Submissions Report

Punchbowl, Affordable Housing, State Significant Development

150 The Boulevard and 34 Dudley Street, Punchbowl

SSD-83256463

7 June 22 - 3pm

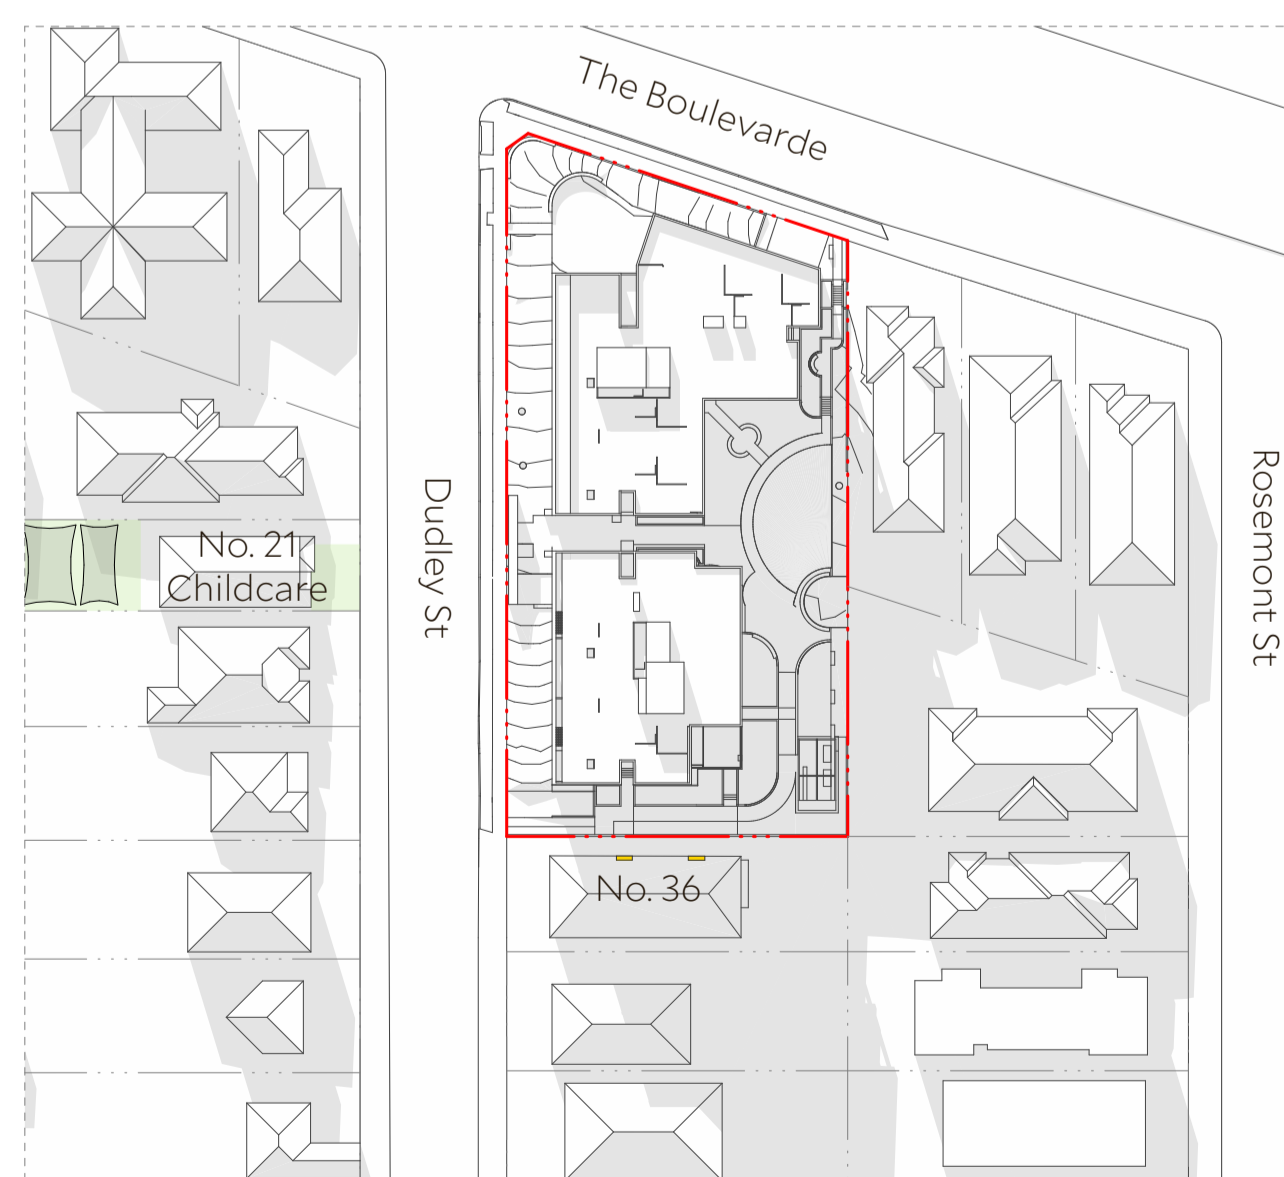
3.2	As raised by Council, further investigation is required to identify all living room windows at No. 36 Dudley Street to verify overshadowing impacts.	All living room windows at 36 Dudley Street have been identified and assessed in the updated Sun Eye View diagrams in the updated Architectural Plans at Appendix B. The updated Sun Eye Diagrams confirm that the proposal will not result in any overshadowing to the additional two living room windows at 36 Dudley Street between 9am and 12pm, mid-winter.

5.5	To the south of the site is a two storey Residential Flat Building (RFB) at 36 Dudley Street. The SSDA Design Report advises this RFB as two northern elevation living room windows (one on each level for Units 1 and 4) which must each receive at least two hours sunlight between 9am and 3pm in midwinter. However, Council's records (file 253/36B) show this RFB as having two additional living room windows (relating to units 3 and 6) and which are the two easternmost windows on the northern elevation. <u>Recommendation:</u> Amended plans be provided that accurately show the living rooms on the RFB at 36 Dudley Street and them receiving adequate solar access in midwinter.	All living room windows at 36 Dudley Street have been identified and assessed in the updated Sun Eye View diagrams in the updated Architectural Plans at Appendix B. The updated Sun Eye Diagrams confirm that the proposal will not result in any overshadowing to the additional two living room windows at 36 Dudley Street between 9am and 12pm, mid-winter. The proposal maintains a minimum of 2hrs solar access to all identified living room windows at 36 Dudley Street, between 9am and 3pm, mid-winter.

No.	Issue raised	Response
		The proposal maintains a minimum of 2hrs solar access to all identified living room windows at 36 Dudley Street, between 9am and 3pm, mid-winter.
